Application for a Non-Material Amendment Following a Grant of Planning Permission

Swakeleys Drive

34228/APP/2021/3129

Non-Material Amendment(s) Sought

Proposed SE Elevation

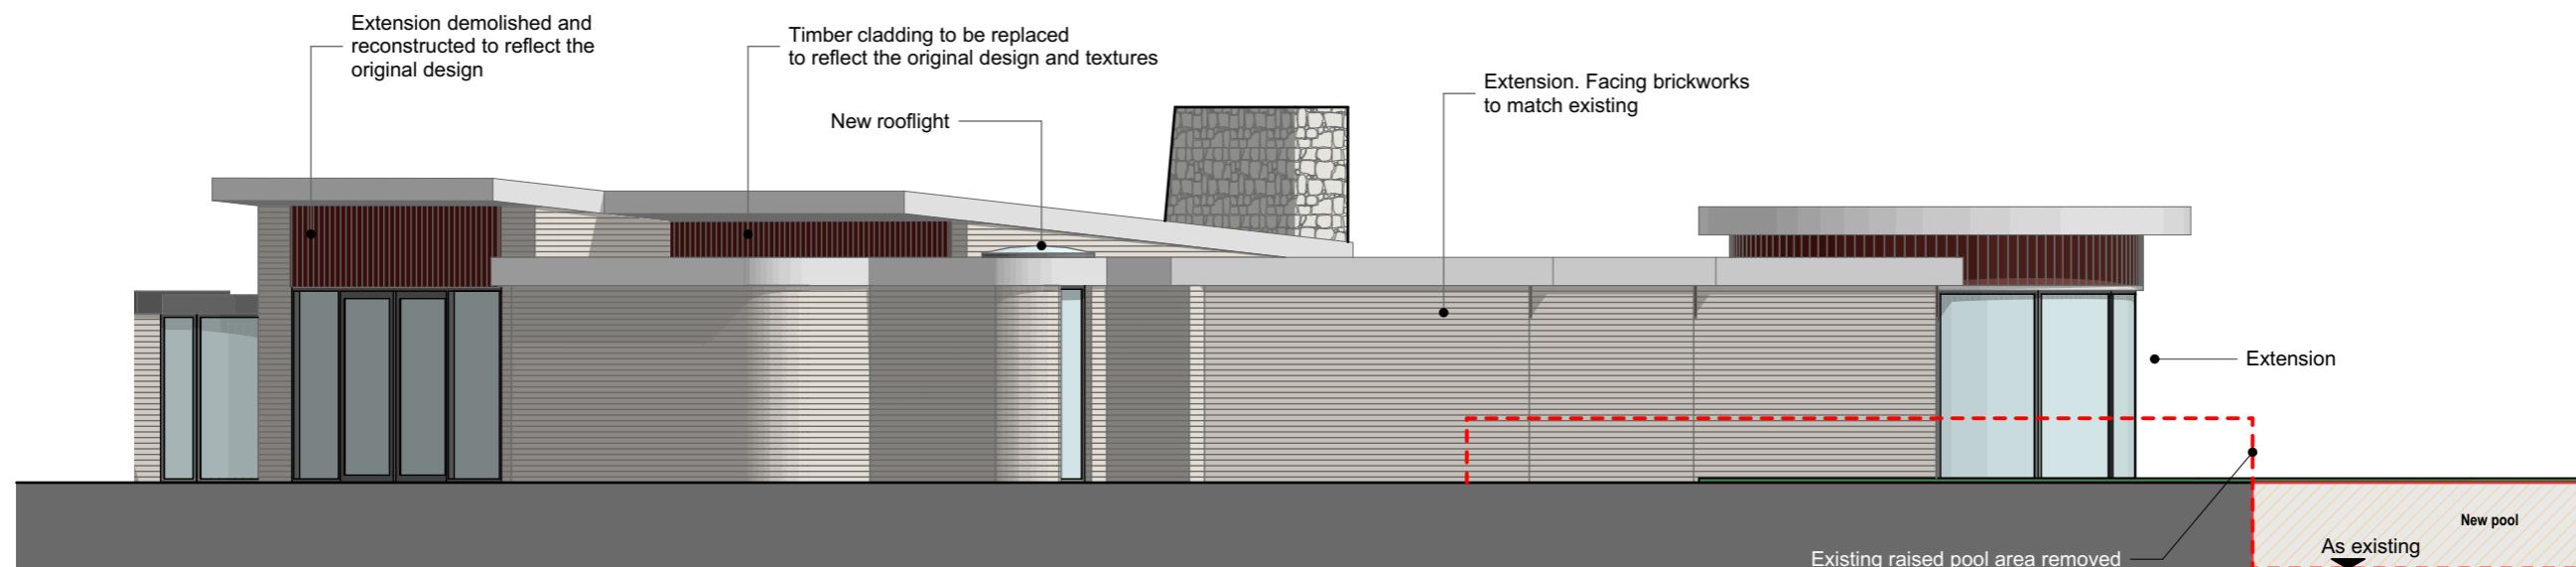
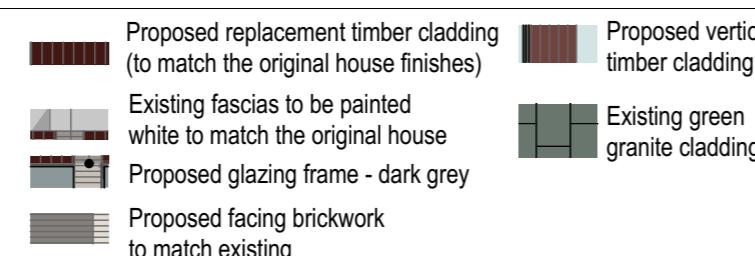
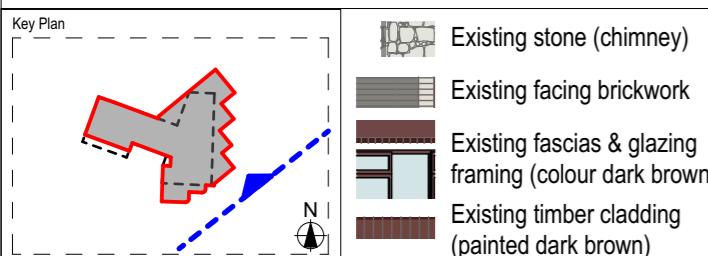
- * Bedroom 1 extension shape changed from a rectangular end to curved.
- * Cladding changed from white to brown.
- * Stone panel added to rear and window removed to same façade.
